Ventilation & Extraction Statement

3 Byron Parade, Uxbridge Road, UB10 0LZ.

**Application for:
Installation of extraction System to Proposed
Restaurant**

PROPOSED SIDE ELEVATION
SCALE 1:100

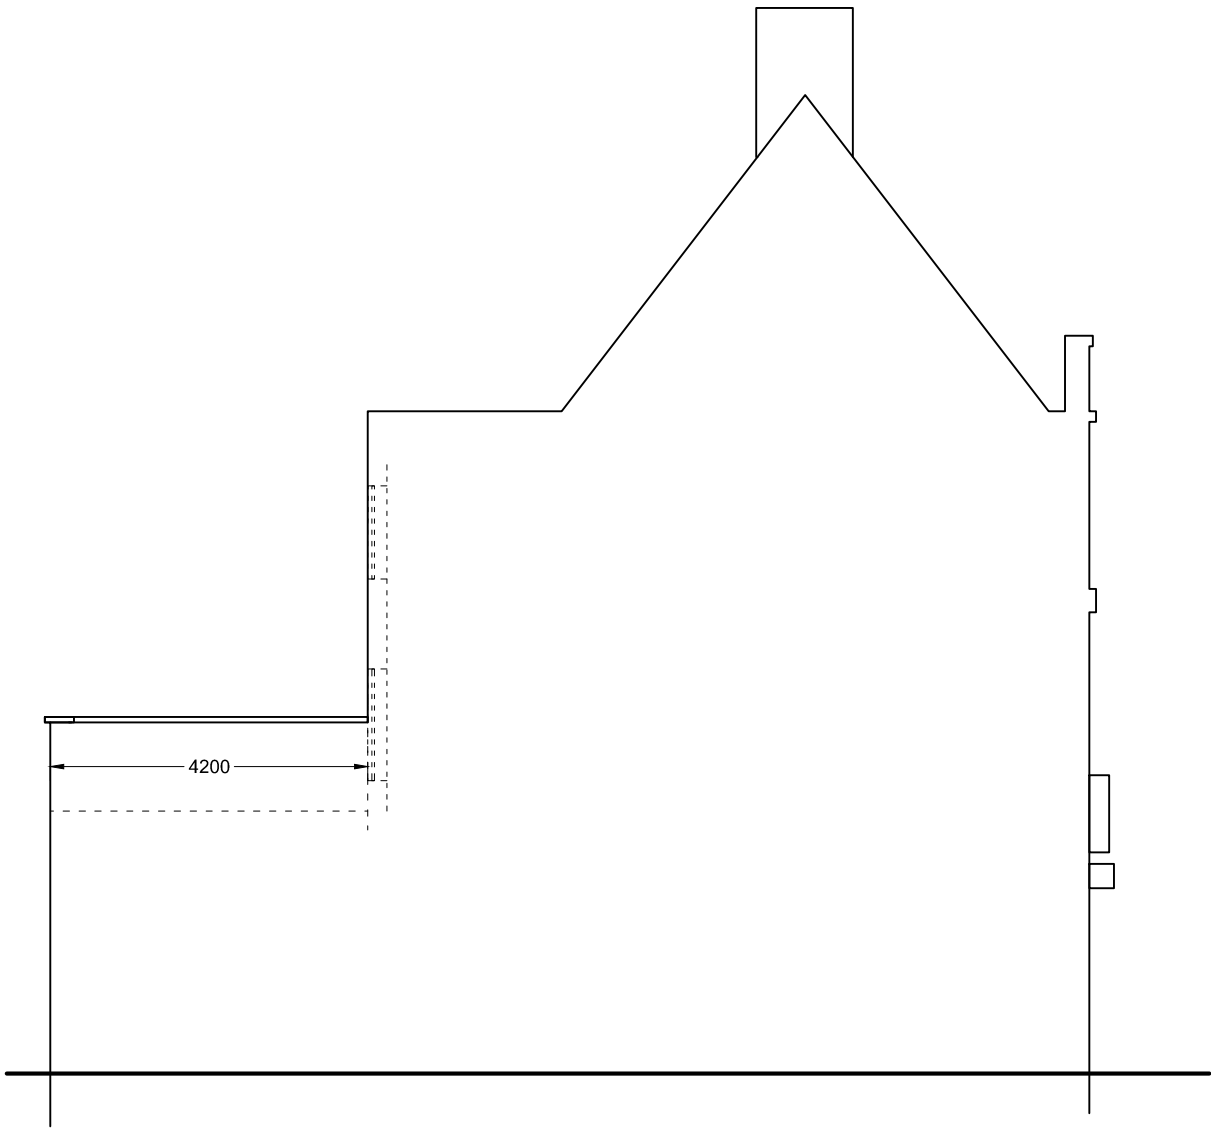
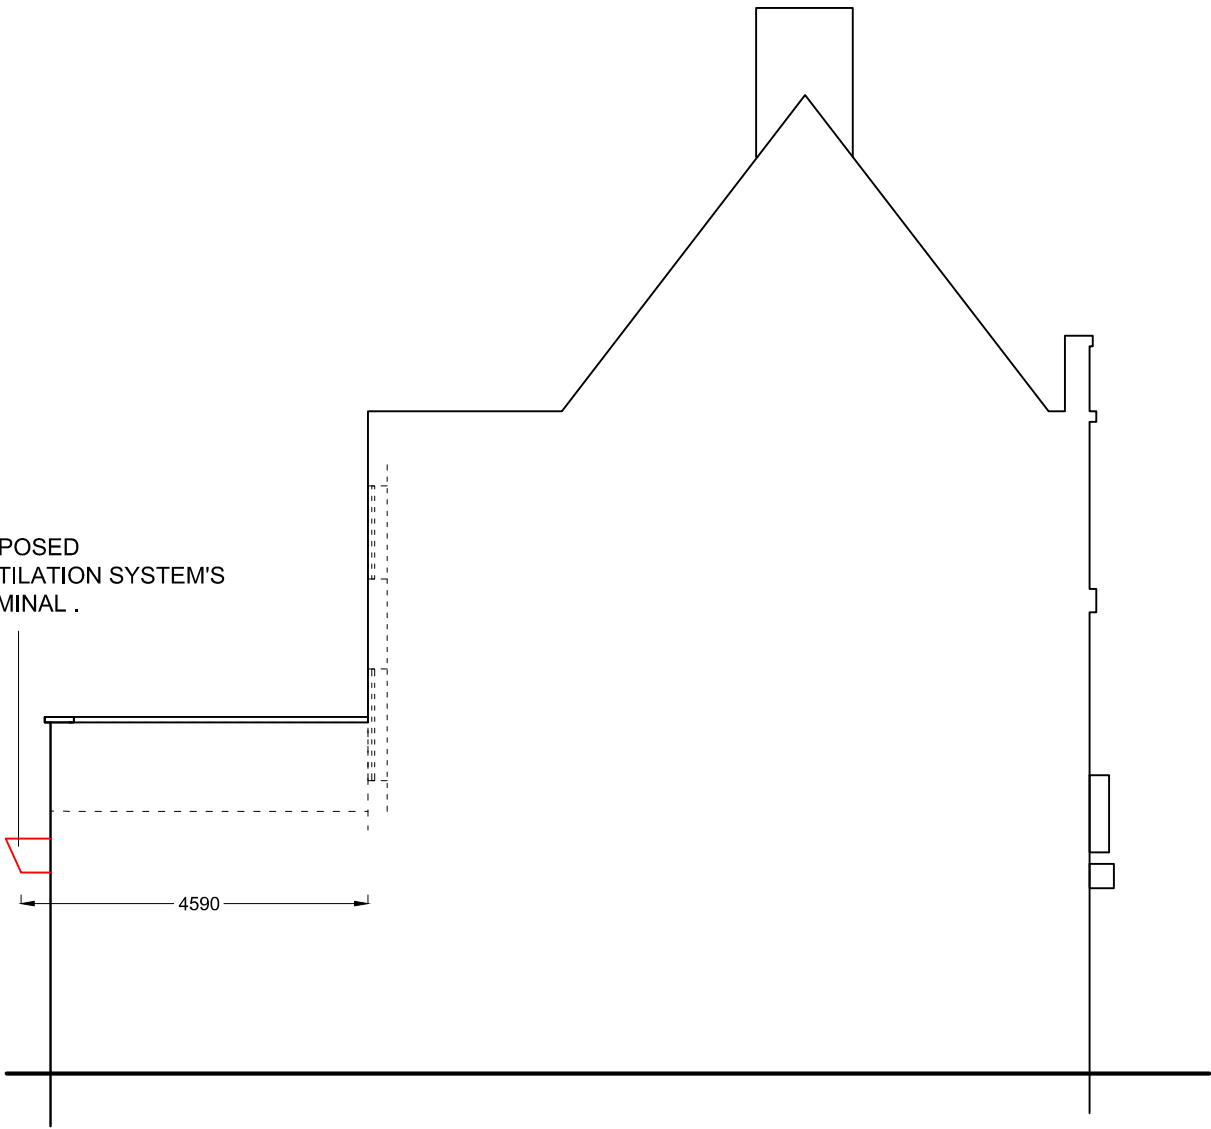
“The proposal, by virtue of the siting and location of the flue and its proximity to adjoining residential occupiers, would be detrimental to the amenities of these occupiers by reason of unacceptable odours, cooking smells, noise and disturbance. The proposal is therefore contrary to Policy DMTC 4 of the Hillingdon Local Plan: Part Two - Development Management Policies (2020)”.

Furthermore EPU Comments in the Officer’s Report regarding Odour says, “I have serious concerns regarding the proposed location of the flue and its proximity to the nearest sensitive neighbouring receptors, the drawings do not give a clear indication of this distance and suggest that the terminal point will be horizontal. Given that the main building elevation is (sensitive receptors) is less than 4 metres away the terminal discharge point is too close to residential receptors and hence there is a strong likelihood of odours cookings smells being detected by residents who adjoin that building”

It wasn’t demonstrated in the previous (Refused) proposal that the distance of Terminal Point to nearest sensitive receptor is in excess of 4m, which is now amended as per actual measurement on site and is annotated in the submitted plans with this application and it is believed that the above stated objection is addressed. Also it is worth mentioning that a similar Horizontal Terminal, at the same distance, for the extractor is being used by one of the close neighboring restaurant.
